Response to Planning Application

From: Arun District Council Greenspace

Application ref: LU/417/21/OUT

Description: Outline application with some matters reserved (except access) for the erection of up to 71 No dwellings.

Figure 1: Site B Open Space Provision

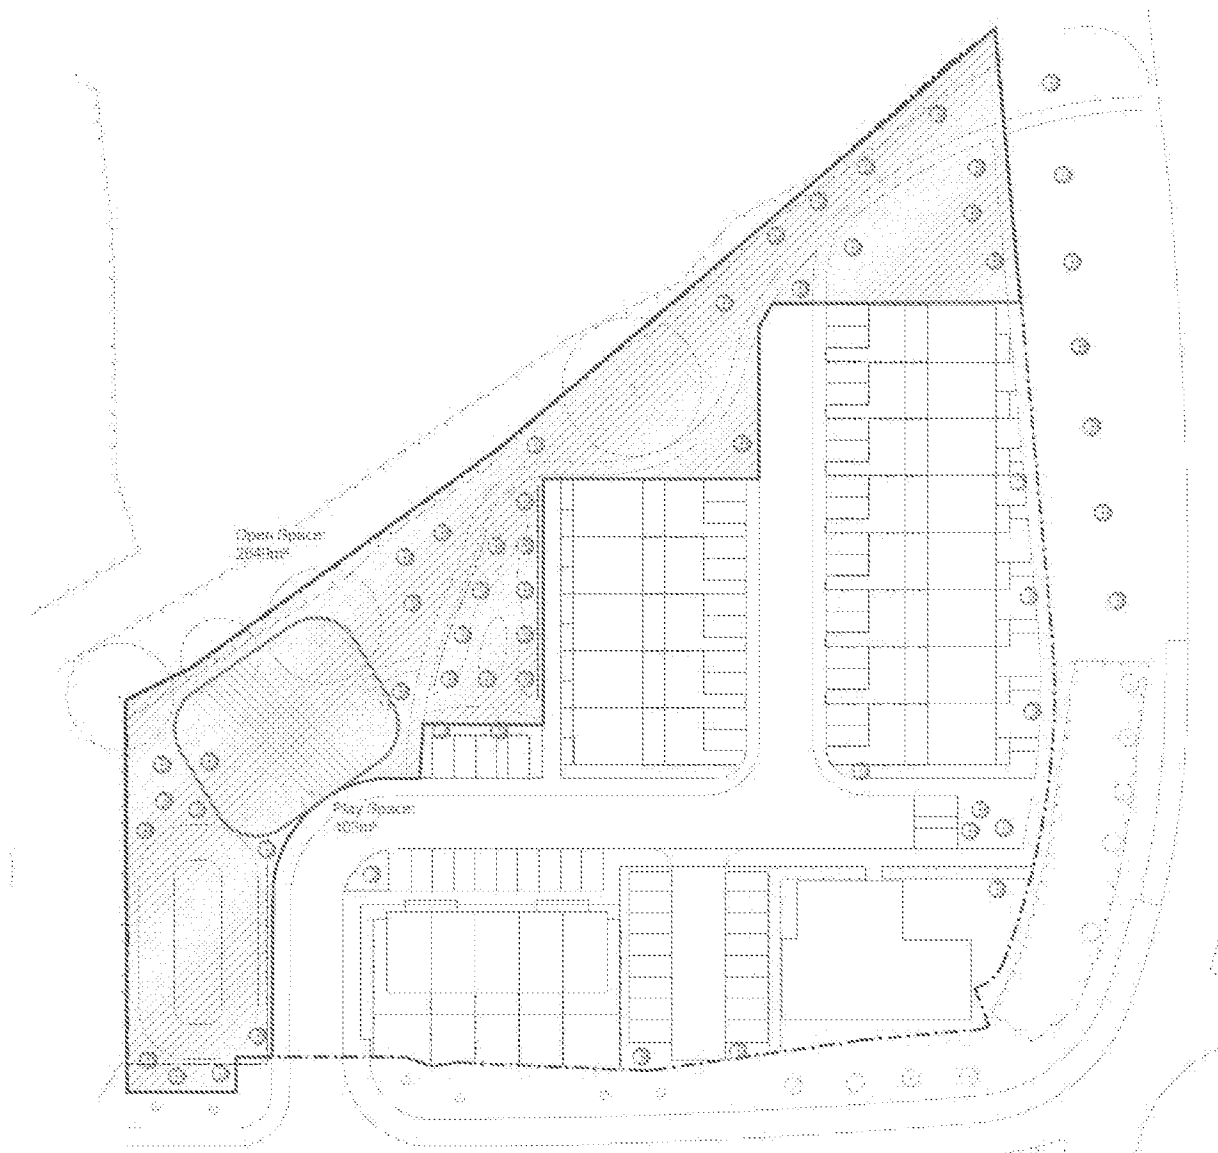
Attenuation pond SuDS are shown immediately adjacent to the LEAP play area which should not be encouraged in such close proximity. SuDS Policy W DM3 of the Arun Local Plan requires development to integrate SuDS into the overall design of the development. The primary purpose of SuDS is to minimise the impact of urban development on the water environment, reduce flood risk and provide habitats for wildlife. SuDS should increase the levels of water capture and storage. It is essential that SuDS do not impact on the usable levels of public open space whilst providing benefit in the correct capacity within the development and should not be included in the 'usable open space calculations' ROSPA or similar should advise on the siting of the play in relation to SuDS areas.

Figure 3. Proposed Layout - Site A

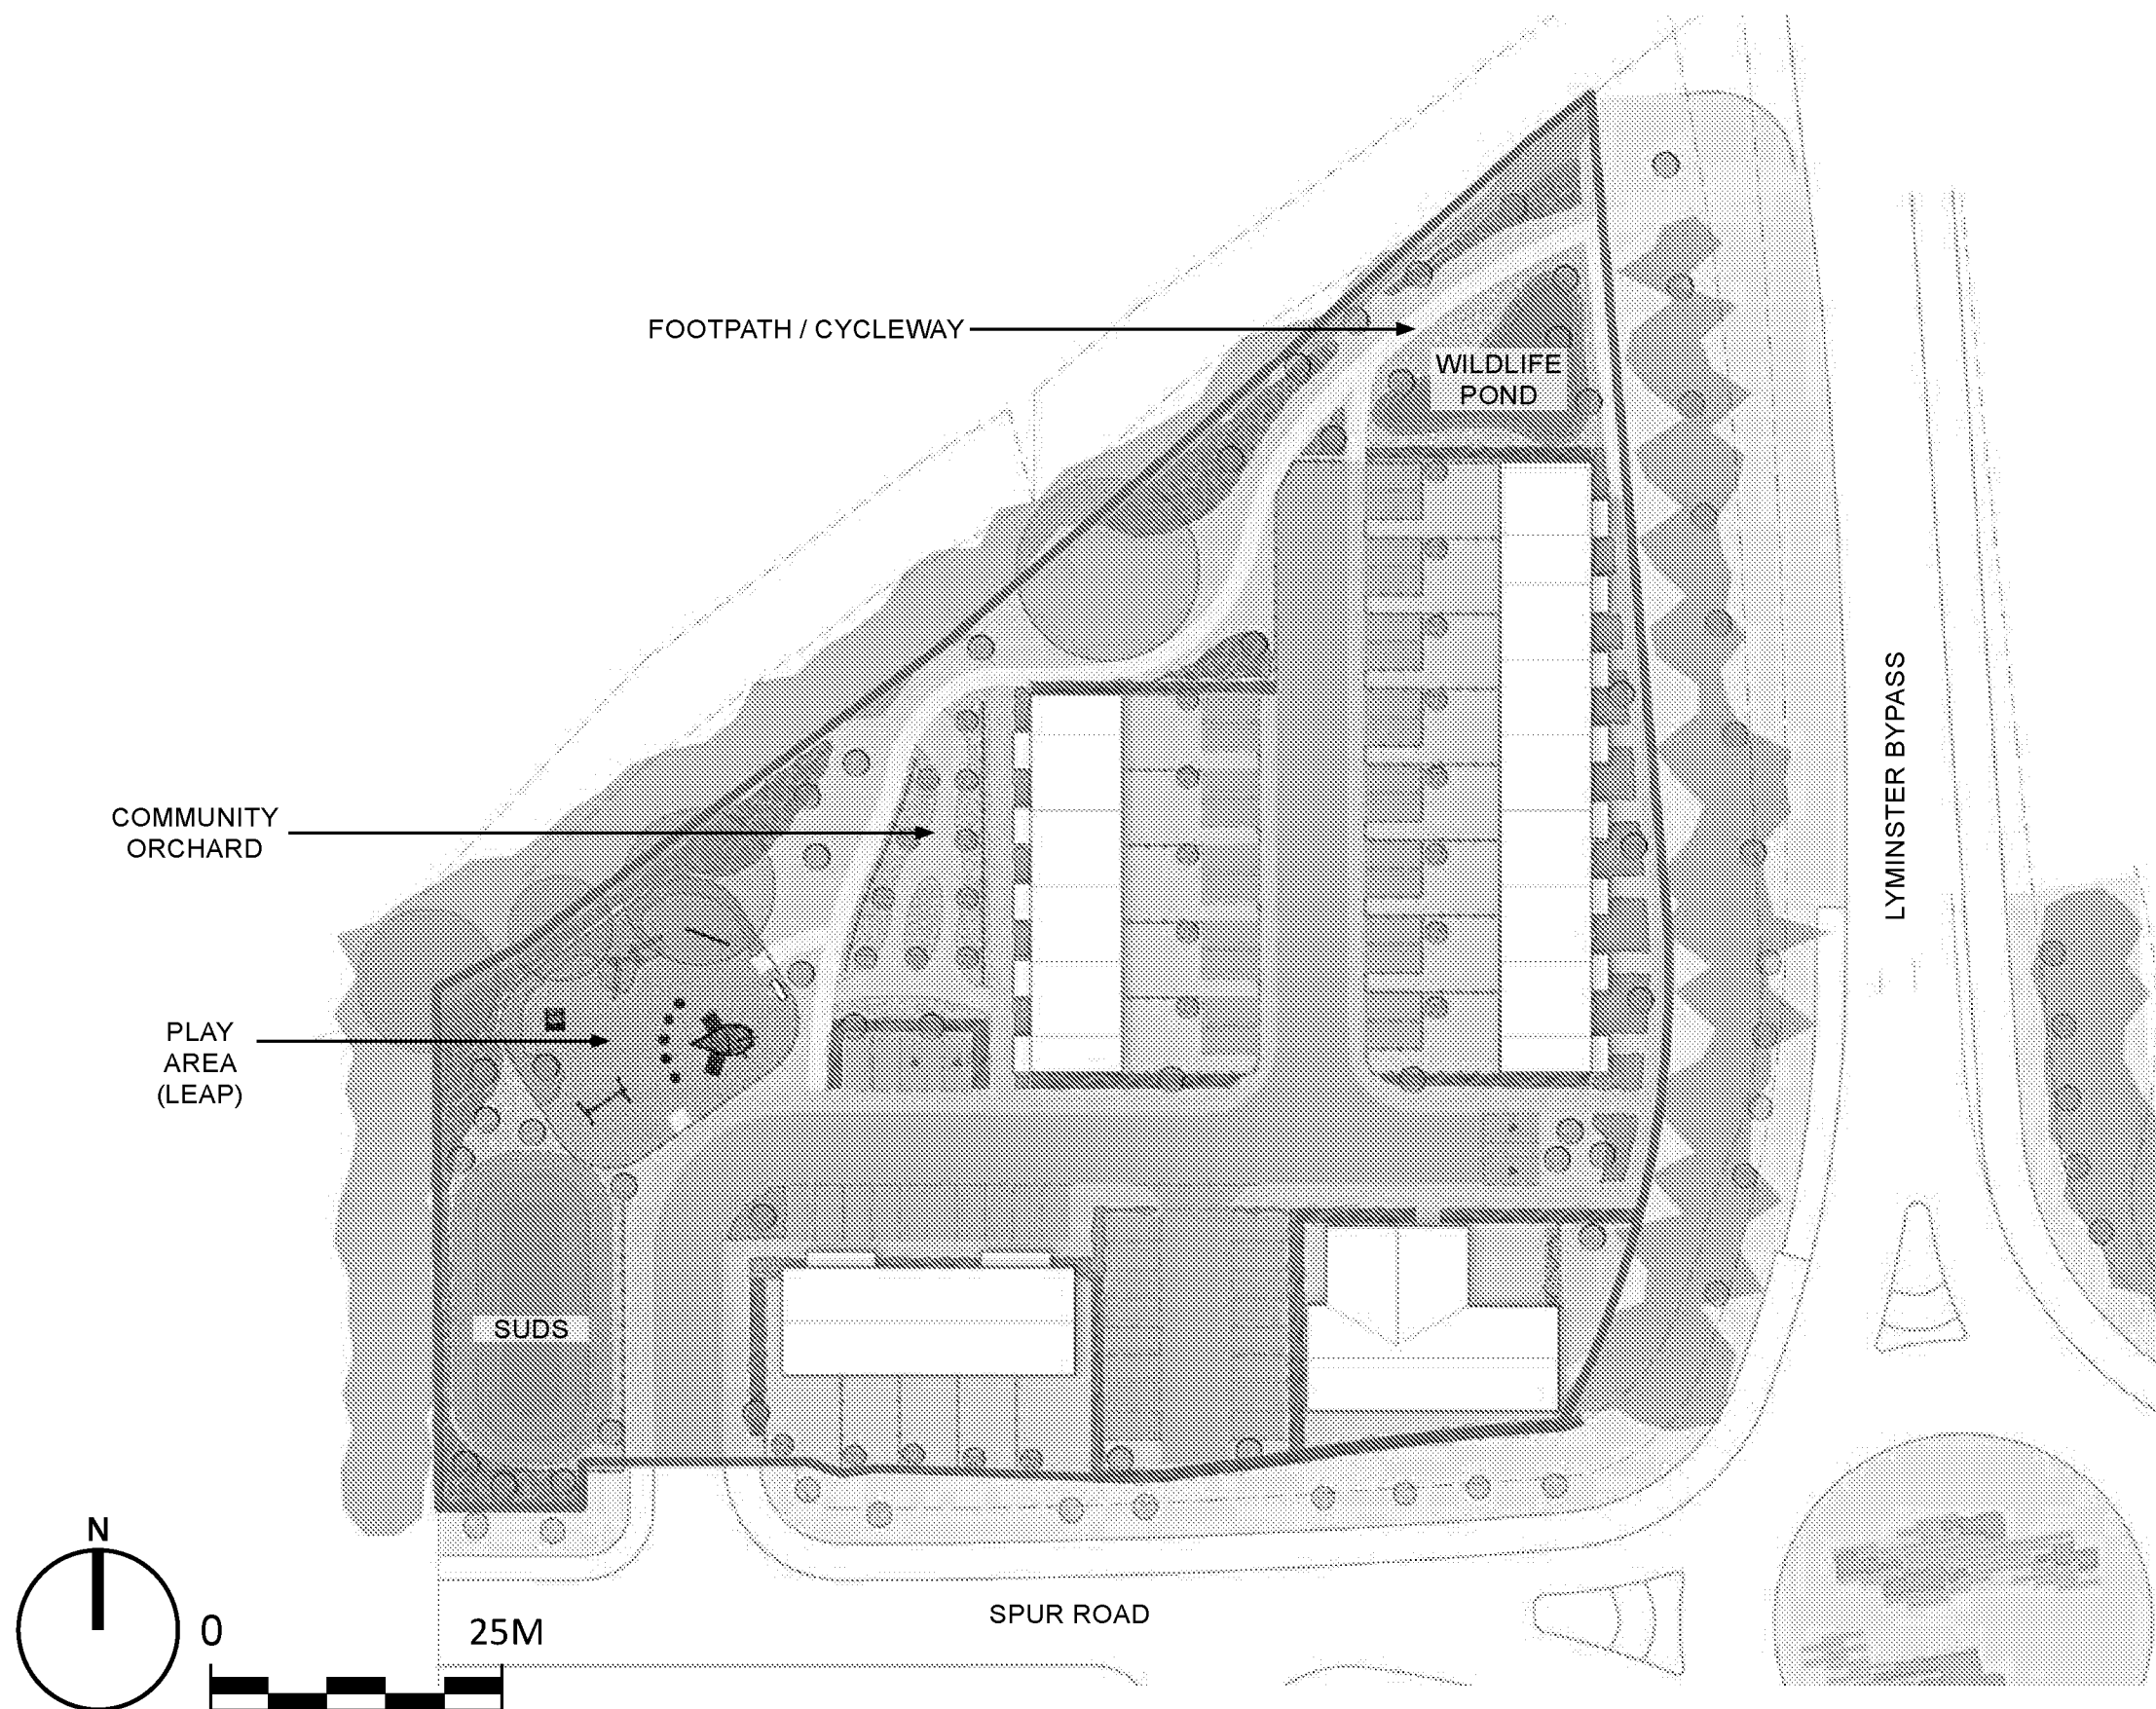
As a minimum requirement this development must cater for its own needs in creating a desirable setting for dwellings. The submitted Coloured Illustrative Landscape Masterplan LLD2373-LAN-DWG-010 Rev 01 indicates the dwelling layout which appear to be very densely situated with very little associated amenity space. The proposals would need to conform to SPD 13 Arun District Design Guide (SPD) January 2021 for good design principles and private dwelling space requirements.

As the proposals are to an area previously earmarked for commercial activity with dwellings now predominantly located along a roadway and roundabout frontage, the aesthetics and suitability of this location for domestic dwellings should be questioned. Very little green infrastructure space would appear available or possible to give these dwellings a buffer zone to the bypass road infrastructure.

The pathway connectivity for pedestrian and wheeled users with meaningful and usable access to the wider surrounds would appear poor particularly in the southern section of the proposed site.
